Re Planning application ref B/36/10
revisions to TREE HOUSE refused
under ref. B/14/10

Revisions to tree house refused under reference B/14/10
Thomas Cottage 104 The Splash Wepham

EAST ELEVATION AS PROPOSED

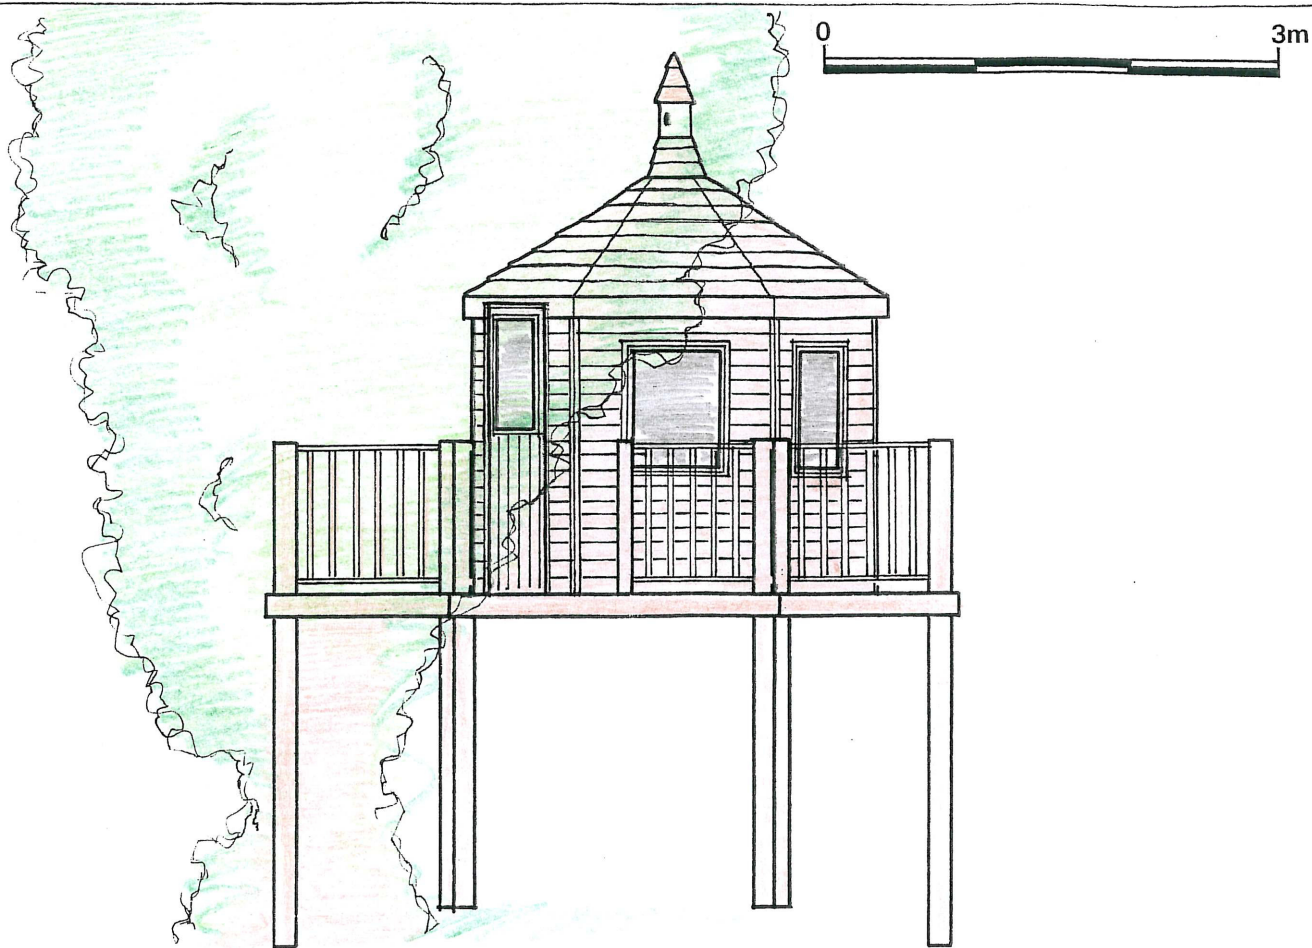
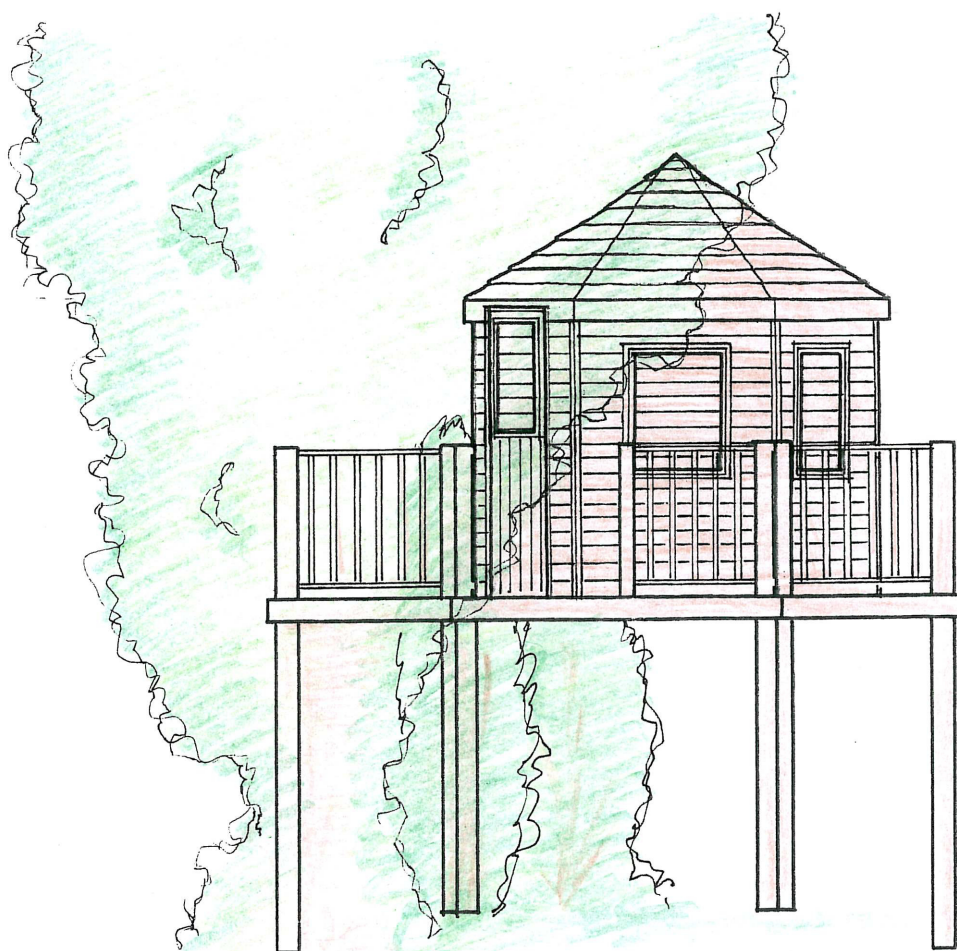
☐
2.2 Amount - In the revised application, the height of the structure will be reduced by 800mm. To achieve this, from the various drawings accompanying the application, it would appear that the top spike only is being removed, and the height of the main body of the structure is actually unchanged. In any event, this "reduction" only represents 13%, and not the 27% the reader is encouraged to believe. ☐

☐
2.6 Appearance - I do not regard the reduction in height of the tree house as significant, particularly as it is only an aesthetic feature which is being removed. The bulk of the height remains unaltered. ☐

SOUTH ELEVATION AS PROPOSED

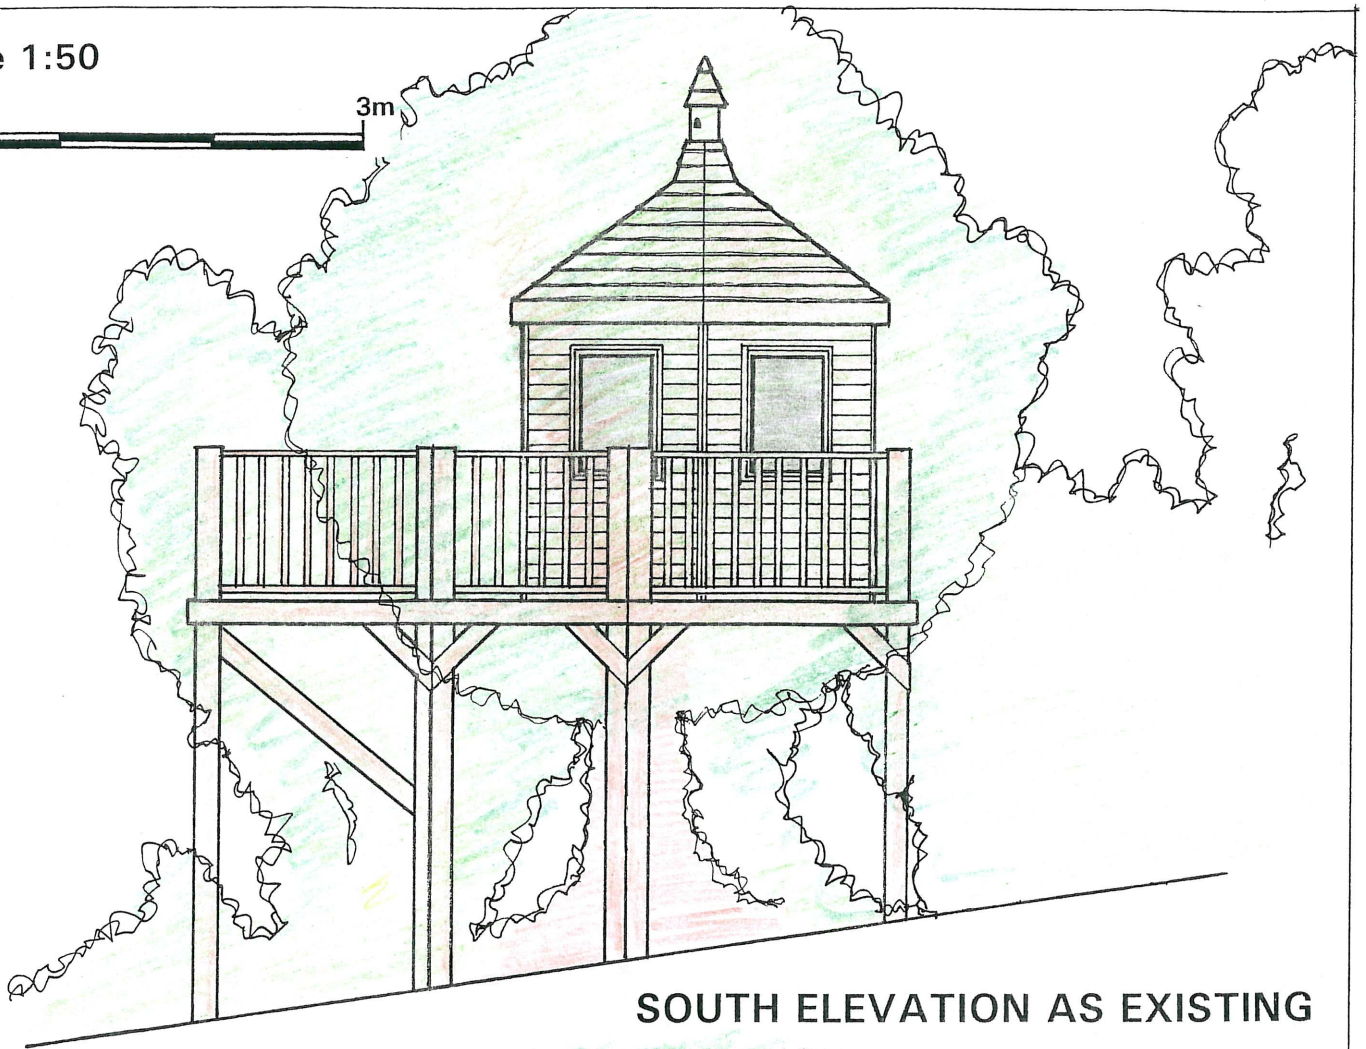
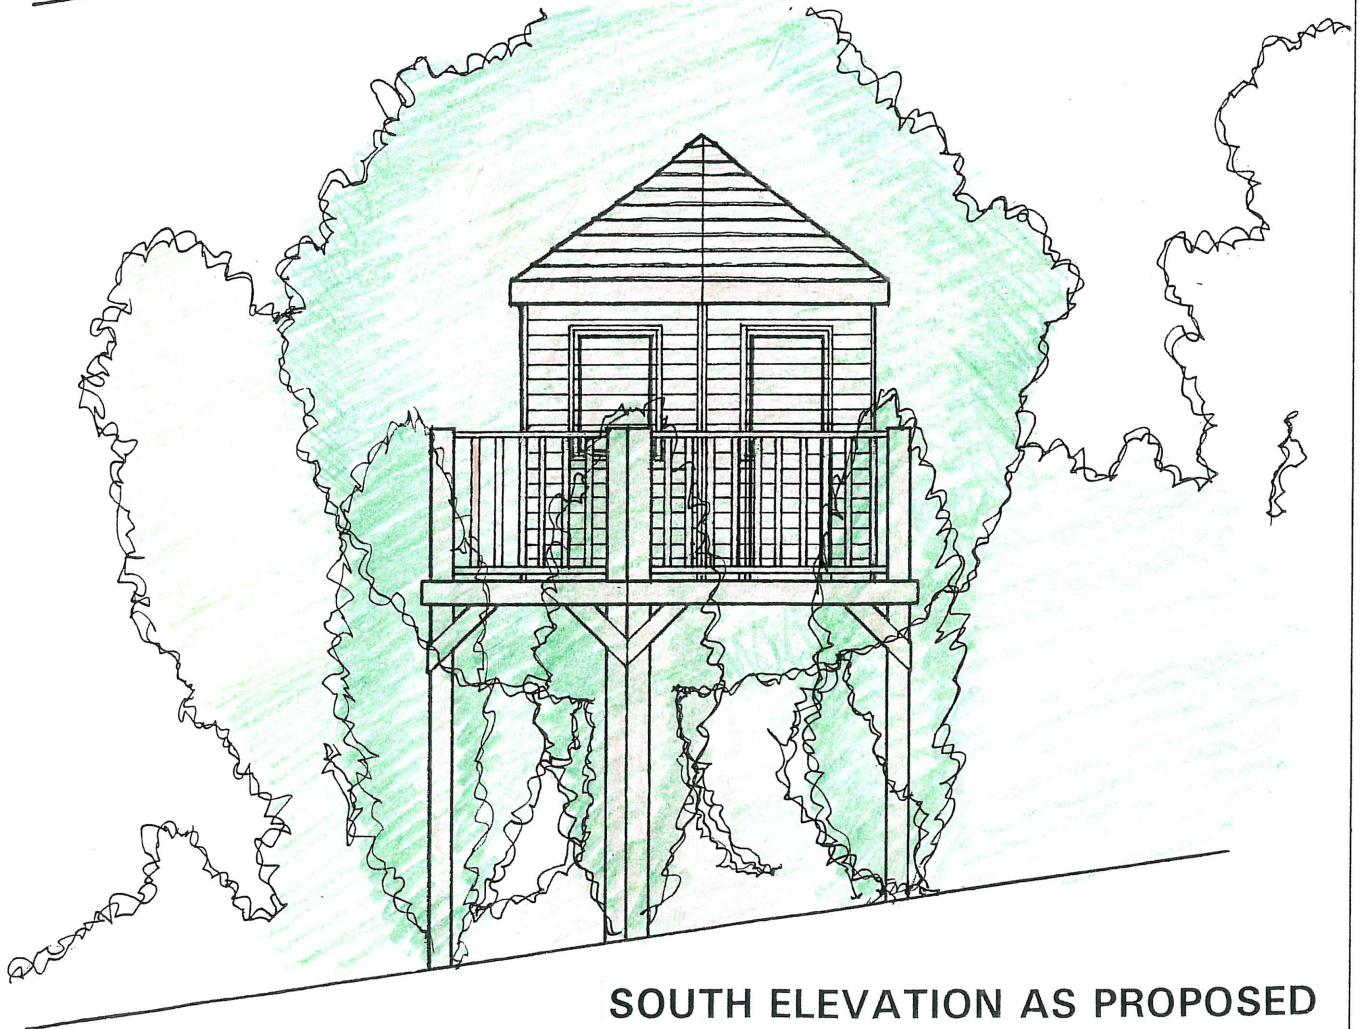
☐
2.3 Layout - I do not feel that the reduction in the visual "footprint and envelope" (I assume this means impact) is anything like significant enough, and feel that it will still be unacceptably prominent when viewed from the south and west. ☐
